Subject: RE: 13-17 Abbeyfield, Richmond Avenue, Bognor Regis - TPJ Developments Ltd - BR/48/22/PL

However, can you advise (a) whether works have commenced and if so what stage they are at; and (b) can you confirm that the changes result in the loss of the two private amenity spaces for flats 1/3 at ground floor as I note the parking area is being enlarged and appears to be around 3m closer to the building but there isn't the same level of detail re the ground floor external area on this application as there was previously.

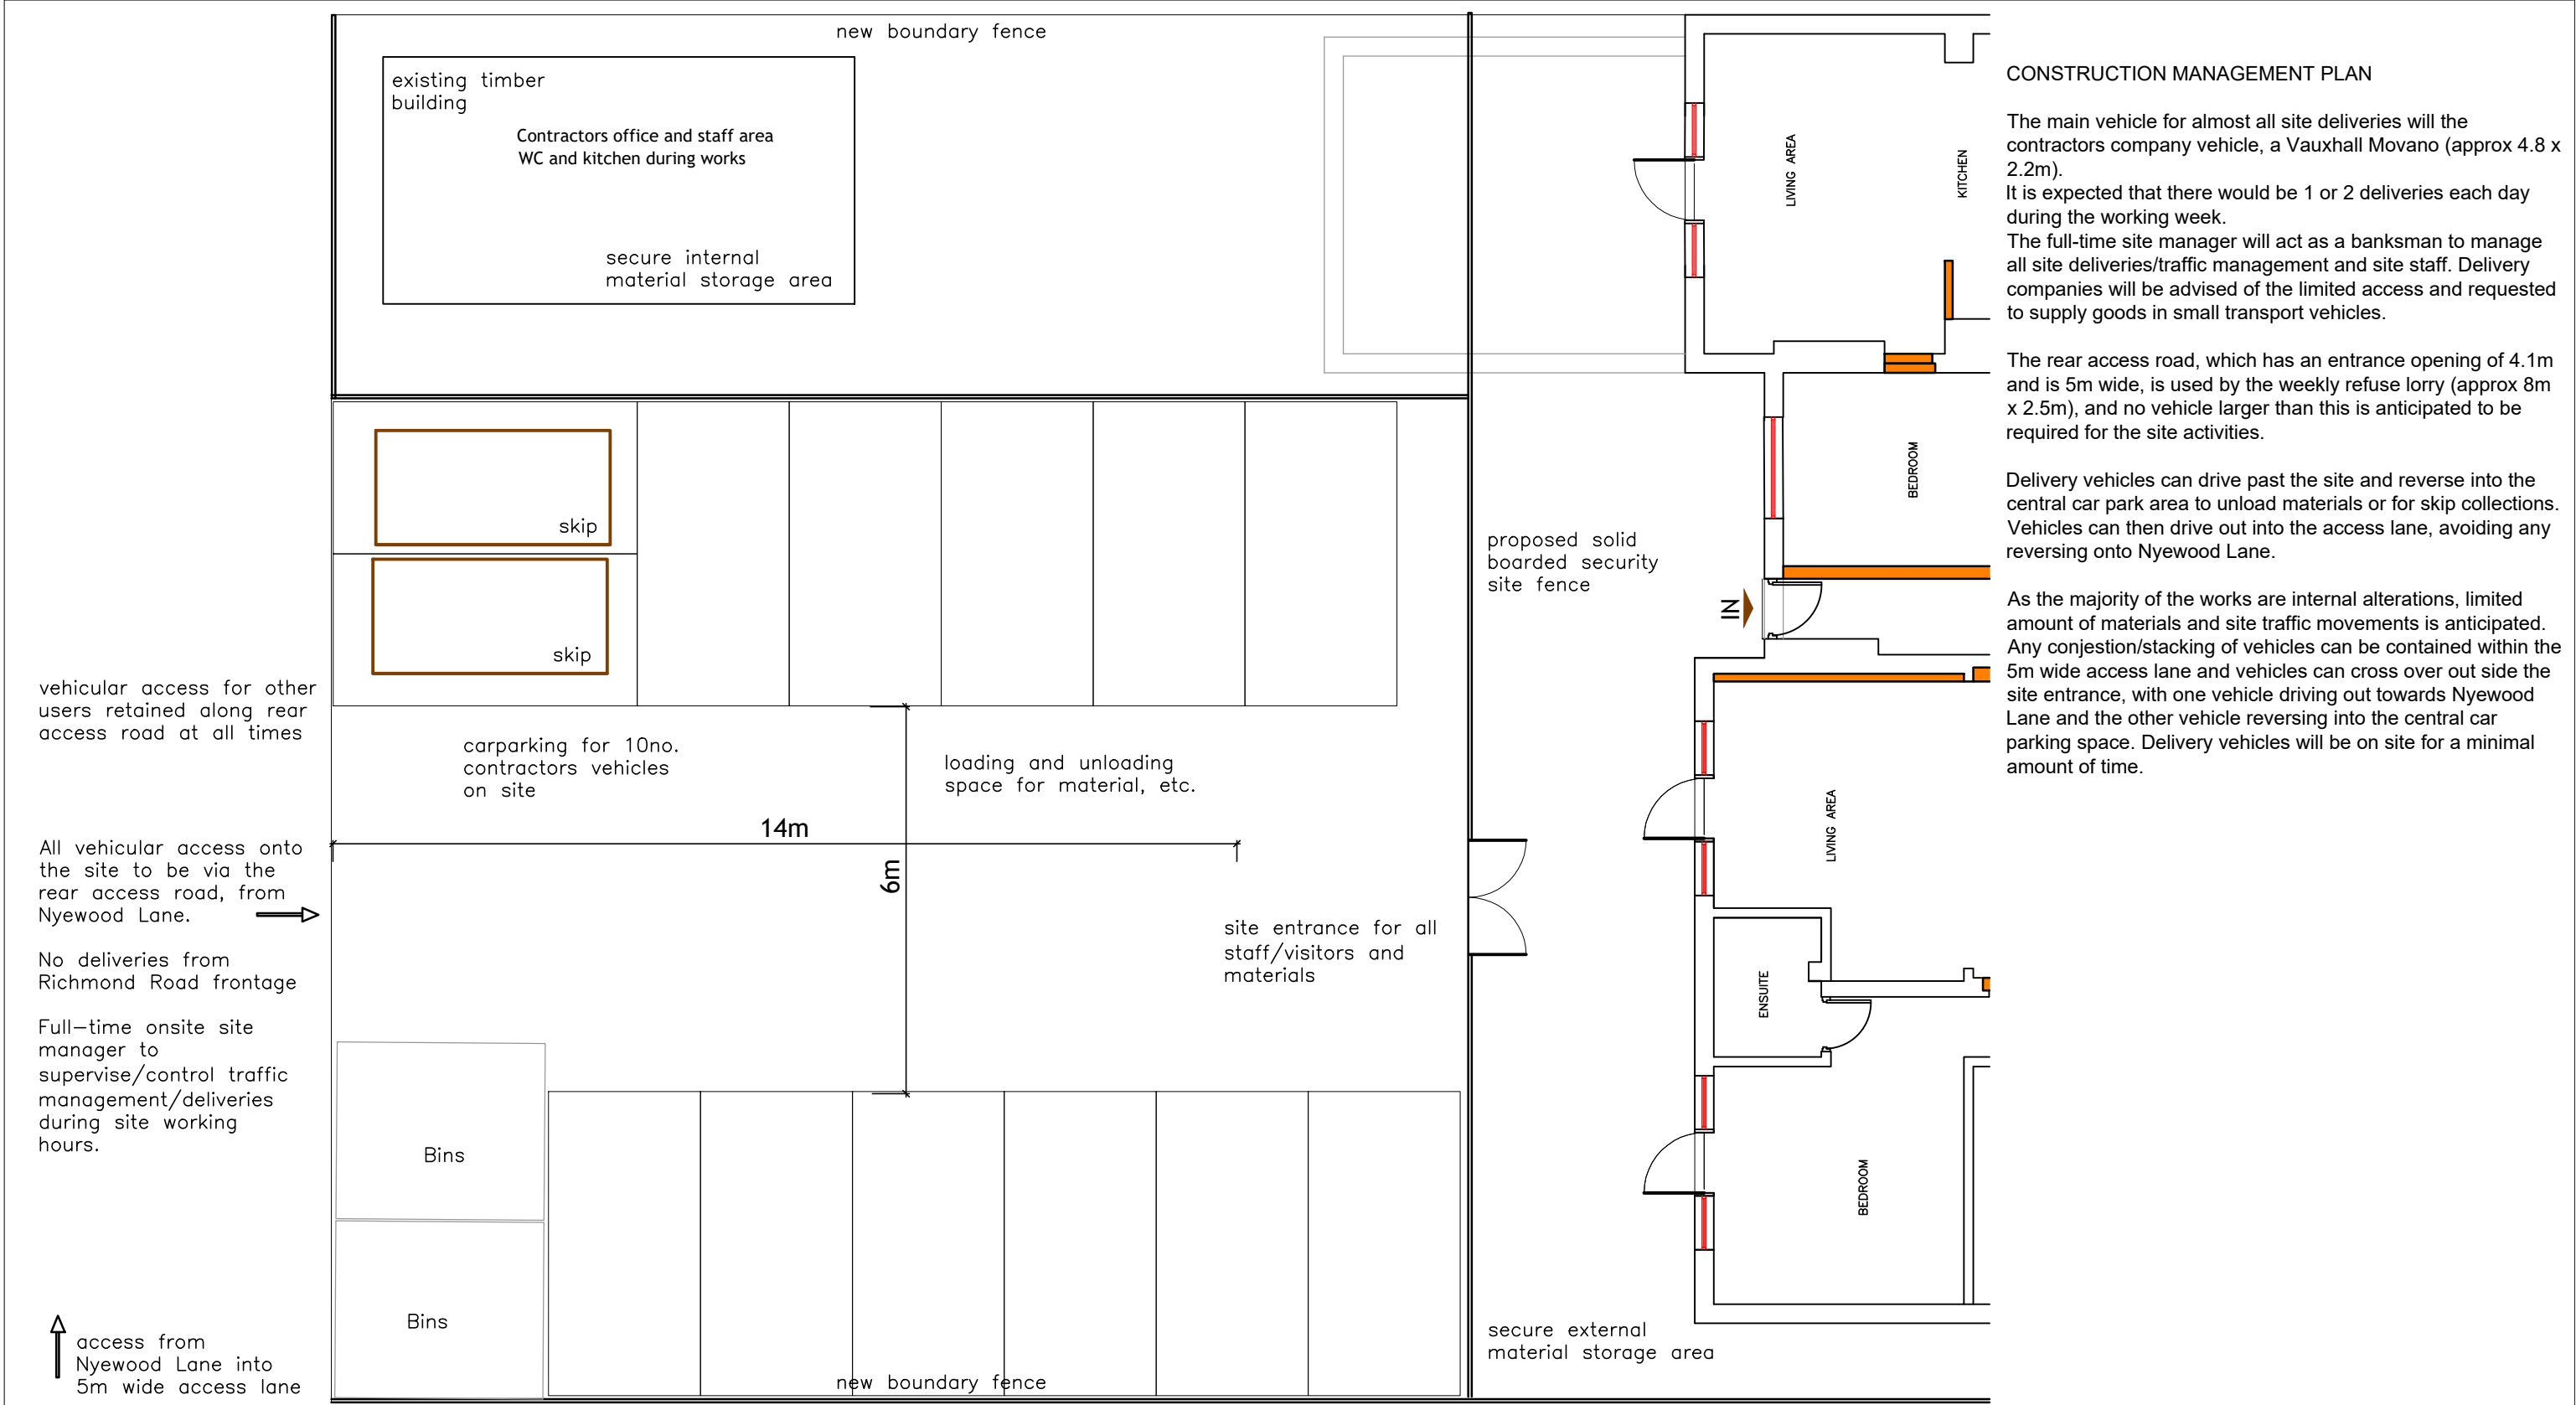
Thanks. Could you update the block plan to show that or provide an amended version of the previous GF plan with the changes to the parking layout and gardens shown so that we have it clear on file what the garden changes are. We won't need to reconsult if you provide this.

- a) Work to the top floor/attic area has commenced but is just at strip out before insulation stage. Nothing is constructed.
- b) Flats 1 & 3 will still have some private outdoor space once the car park spaces have been allocated.
